THE SHOP'S AT MERIDIAN RANCH

FILING NO. 1, LOT 4
LANDSCAPE PLAN
EL PASO COUNTY, COLORADO.
FALCON, COLORADO

DRAWING NO. 2
LANDSCAPE PLAN

DRAWING NO.
1
 SITE DEVELOPMENT PLAN

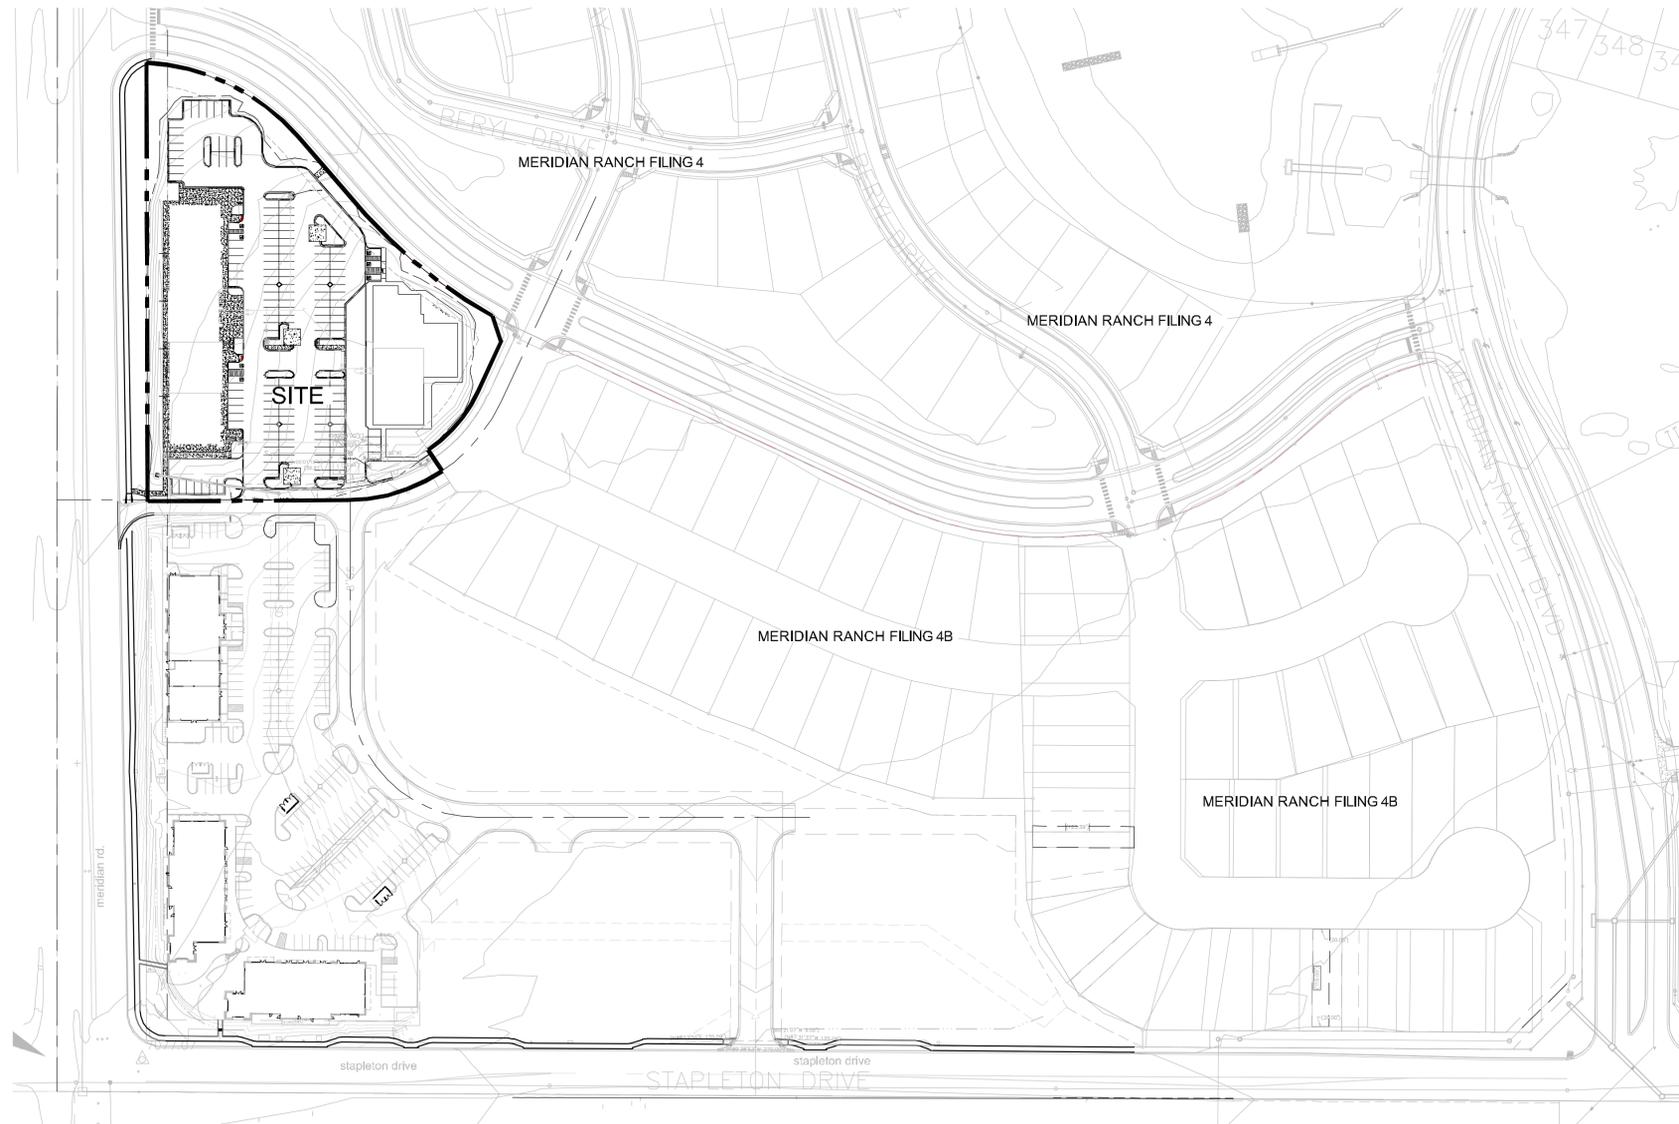
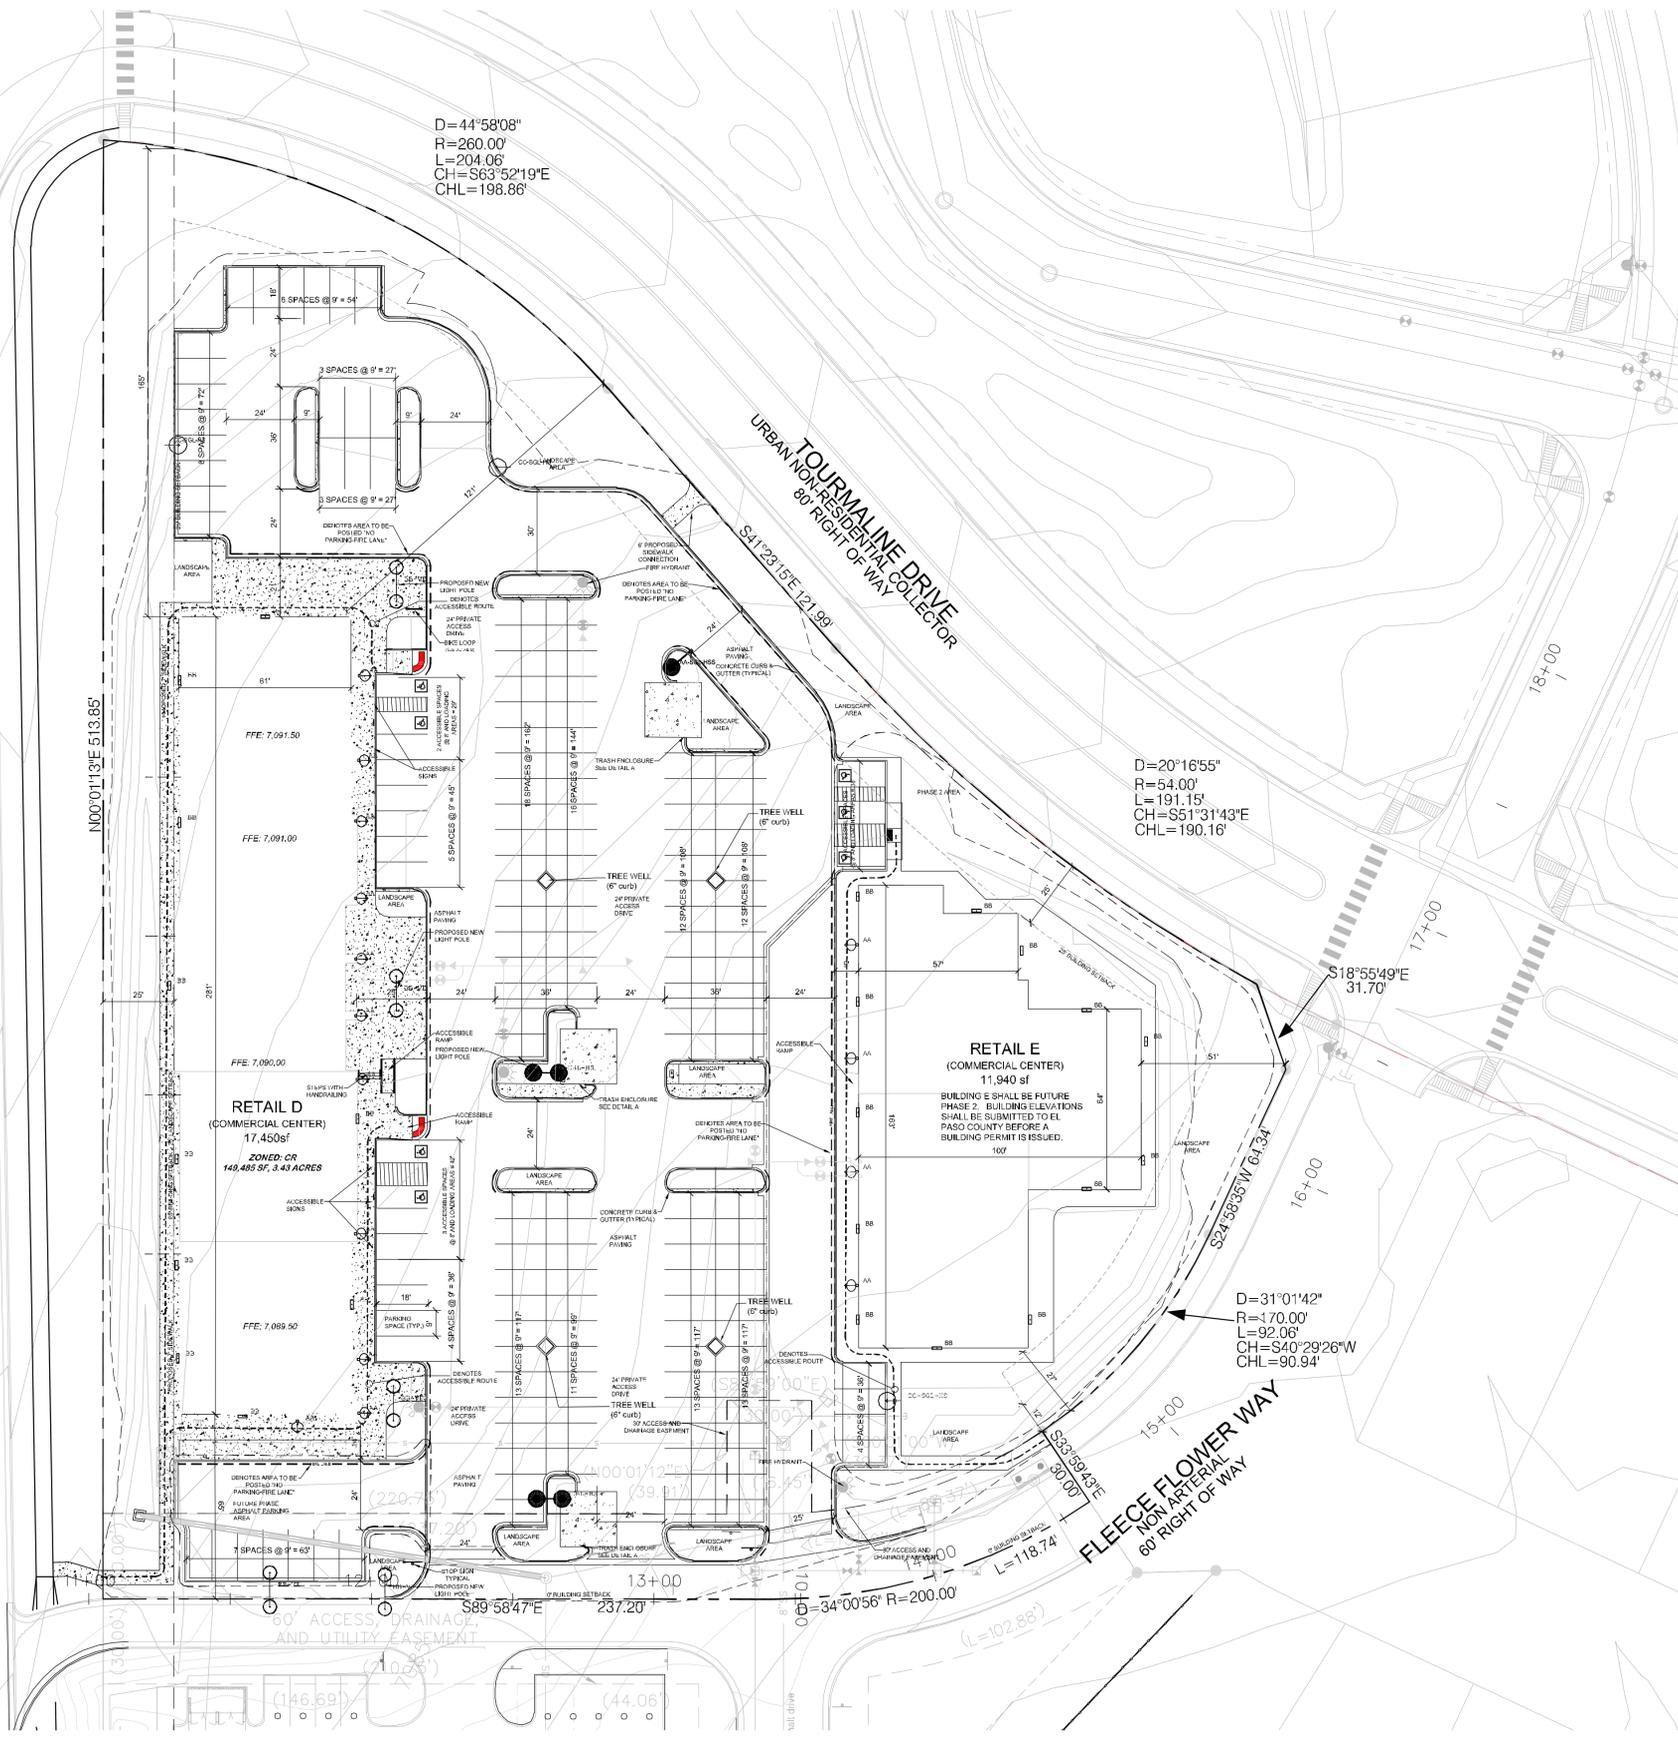
Show how you are going to meet these requirements. Are the shrubs replacing trees?

Show how you are going to meet these requirements. Are the shrubs replacing trees?

Mark 25 foot buffer.
